Planning Application Ref: BR/45/20/T

Location: Orchard Court, 1-4 Orchard Way, Bognor Regis, PO22 9LP

Description of works: Reduction to limbs by up to 1m to 1no. beech Tree (T1) and 1.5m to 1no. walnut tree (T2) over Orchard Court from 106 Chichester Road

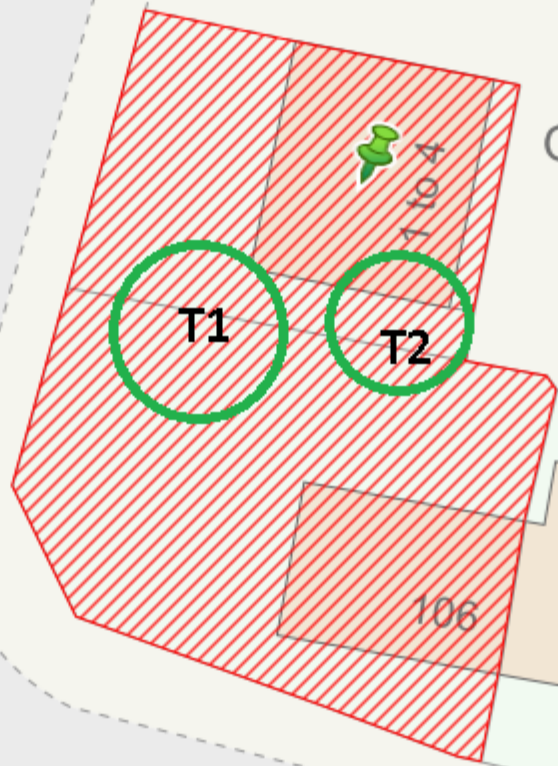
- **T1** - Outwardly and from a distance (restricted view) appears to be in a fine physiological state. One of two beech trees providing mutual support and sharing an attractive profile. Subordinate to its companion and with asymmetric form. Together they are a landmark feature, growing from within raised garden alongside a busy public highway junction. As such, they have high amenity value.

- The work proposal does not explicitly describe which limbs are to be reduced. Nor are there any reasons given for the work. Although it can be assumed that greater clearance of the building to the north is being sought, the specification as it stands is open to interpretation and to grant consent would in theory permit all branches extending over into Orchard Court to be reduced by 1metre.

- Building clearance is adequate at present, but some reduction of lateral spread to improve conditions for residents in Orchard Court is entirely reasonable and can be achieved without undue detriment to the visual amenity provided by the tree.

- **T2** - Outwardly and from a distance (restricted view) appears to be in a fair physiological state. Slightly asymmetric from and with a relatively unmodified upper crown. Truncated limb on south aspect giving rise to the bulk of boundary/building overhang.

- Similar issues to T1 in respect of work description. Will need to be revised to achieve likely best outcomes.
- Discreetly located between neighbouring dwellings and partly obscured from public view by T1 and its companion.

- The likely intent behind the work proposal is reasonable but the specification needs to be amended to ensure that whoever is appointed to undertake the consented work is in no doubt as to what has been approved, to ensure no loss of public amenity on completion.

- As it stands, I recommend **REFUSAL** for this application.

- I would like to see the applicant submit a revised work specification such as detailed below, which would seem to address their concerns whilst preventing a diminution of the trees landscape and public amenity value:

- Reduce back lateral extent of crown on north aspect only, pruning selected branches and restricting wound size to max.75mm diameter and to leave a minimum of 5m radial crown spread.

- Reduce back branches as necessary to achieve a maximum clearance of 2metres from adjacent building/roof (Orchard Court).
